CITY OF ALBUQUERQUE

June 5, 2012

Re: Mountain America Credit Union Grading & Drainage Plan, (D20-D010A)
Parcel B, Parcels A, B & C Ventura Plaza (P.E. Stamp: 5/18/12)

SHEET TITLE: **GRADING PLAN**
SHEET NUMBER: **C-201**
PROJECT: 2013.0048 ORIGINAL ISSUE: 05/19/2012
D20/DC10A 1-13

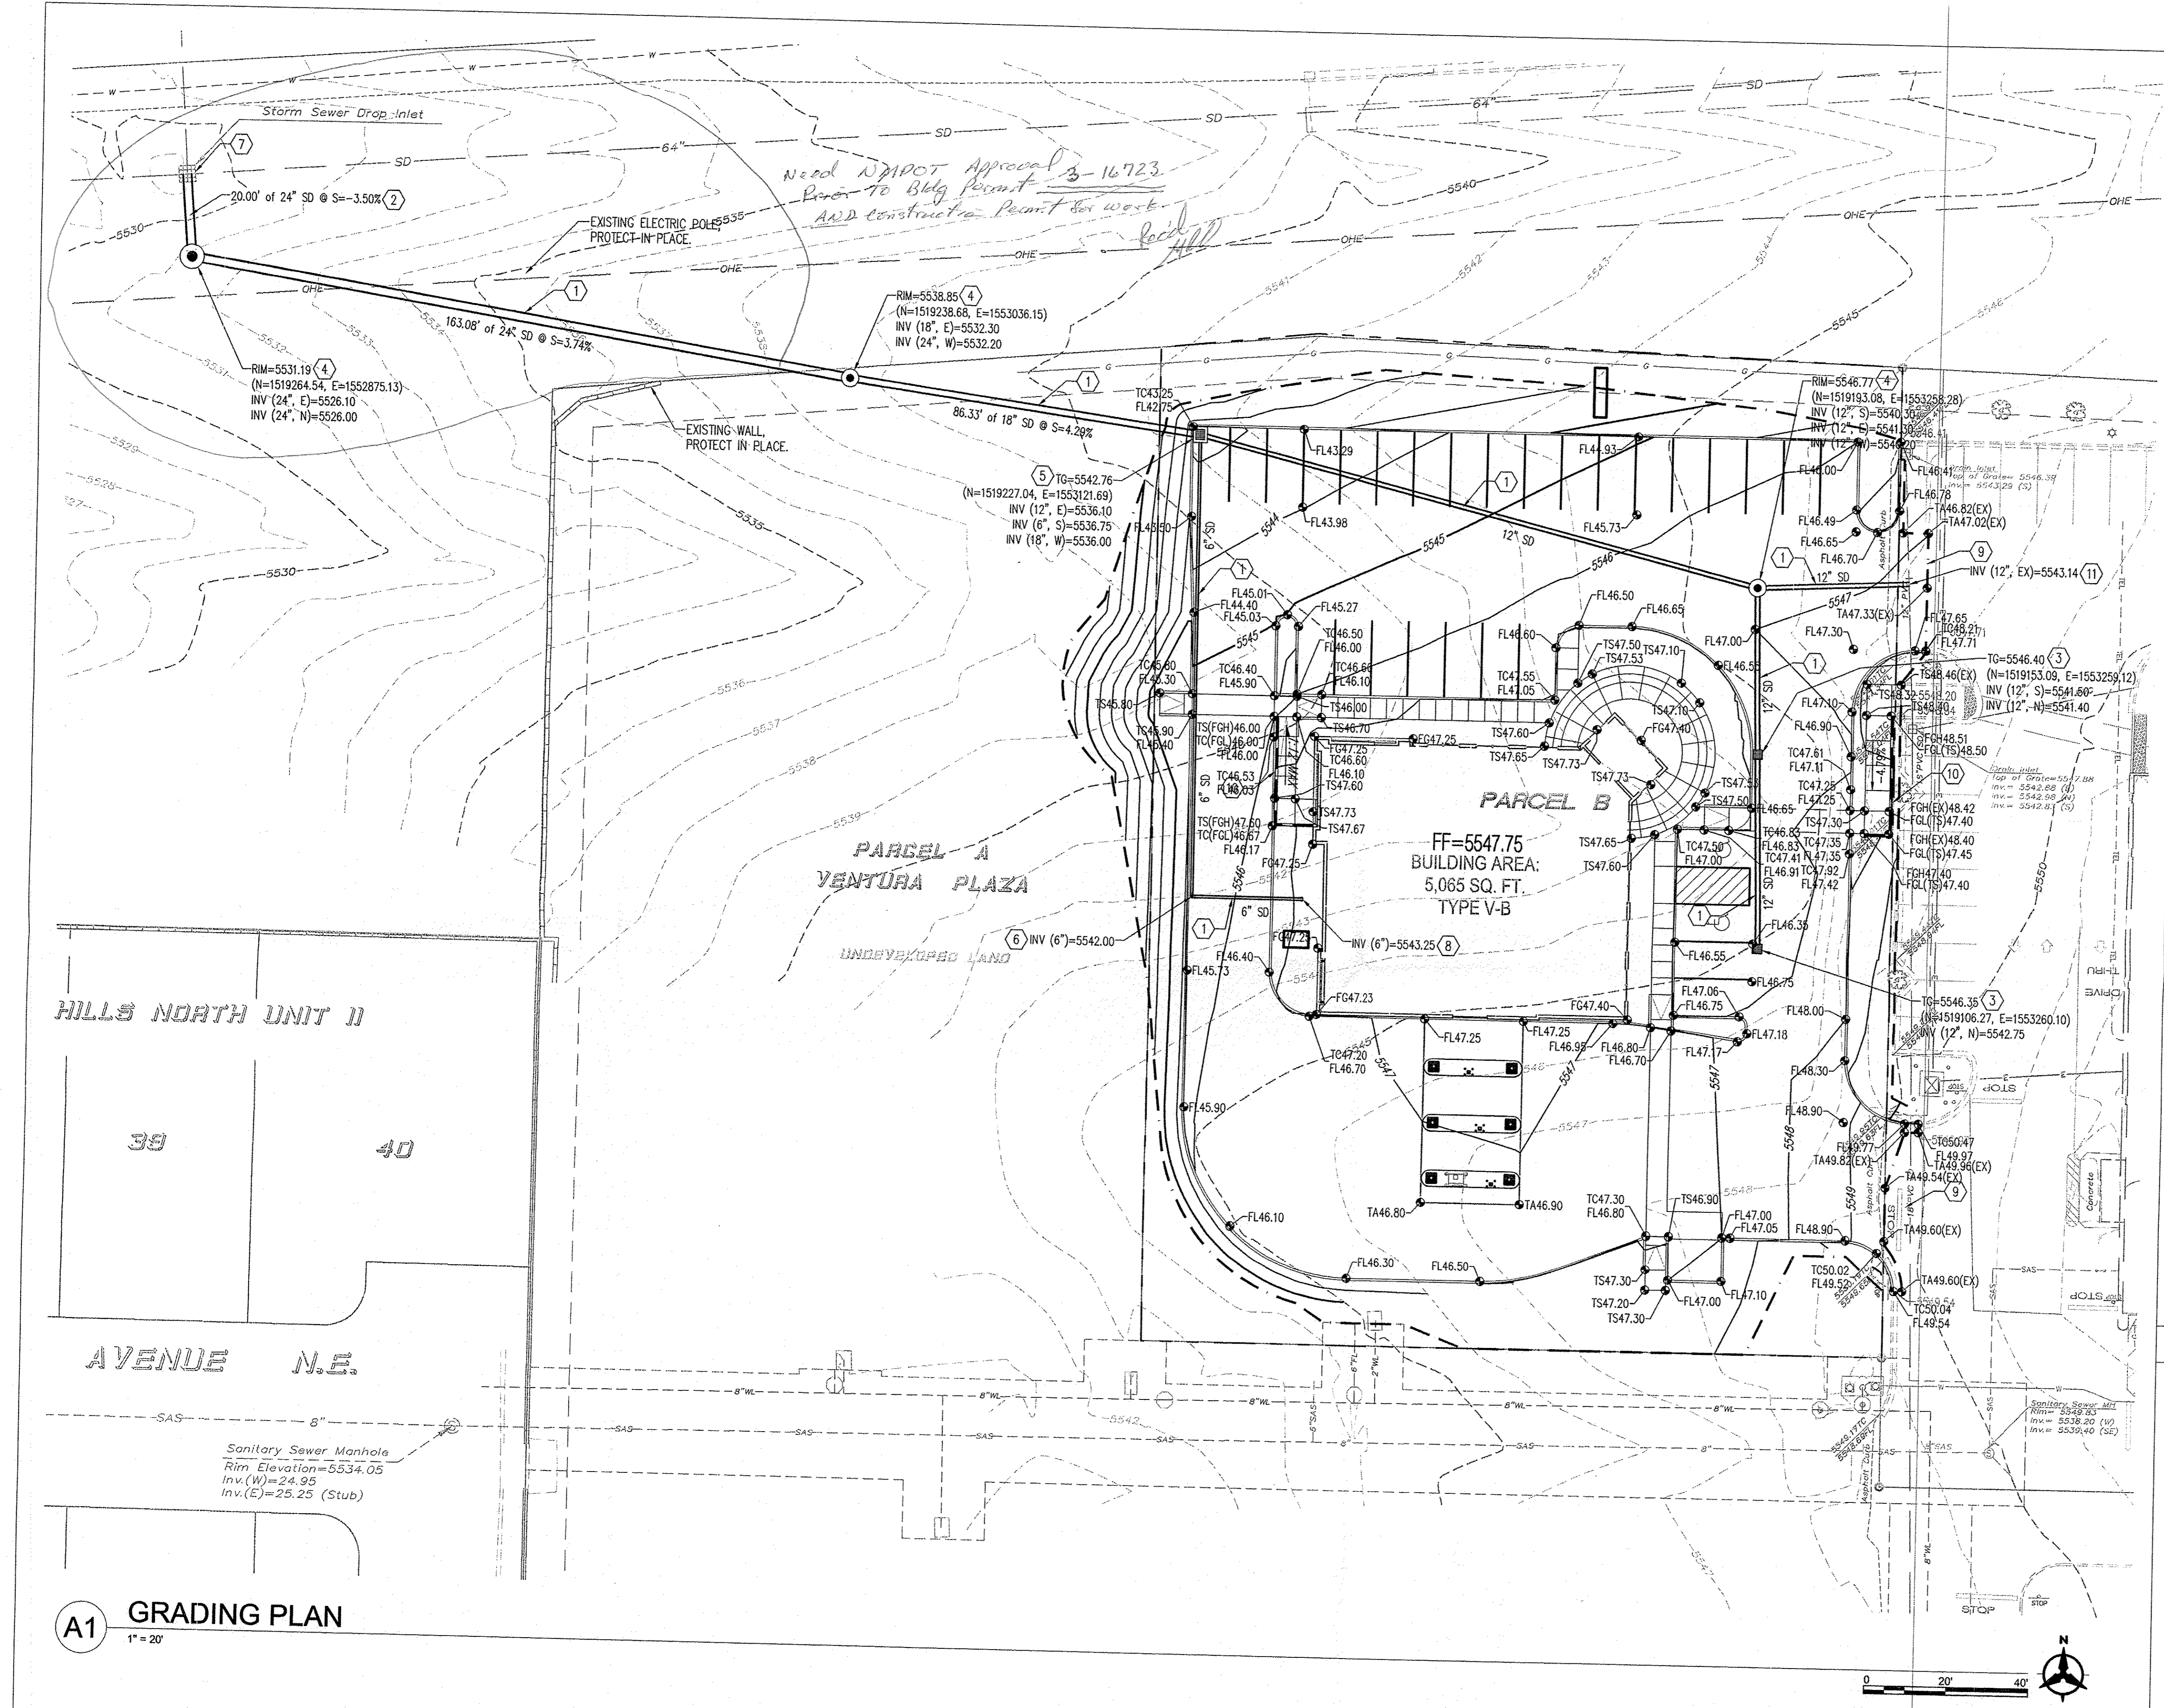
2. Since the 24" storm drain outfall at the NW corner of the site will tie into the 64" storm drain within the Paseo del Norte R/W, it will require approval and a permit from the NM-DOT, District 3. (Contact [Timothy Trujillo](#), Drainage Engineer: 505-798-6690)

3. Prior to City approval of this plan, we require documentation (or email) from NM-DOT of their concurrence with work proposed within their R/W, and citing the PE Signature date on the plan that they approve.

4. This plan lacks a few presentation features required for Grading and Drainage Plans, per the DPM Chapter 22. Please review and update any revised submittal. If DOT approves this plan, I ask that you at least add a location map to the as-built Certification Plan.
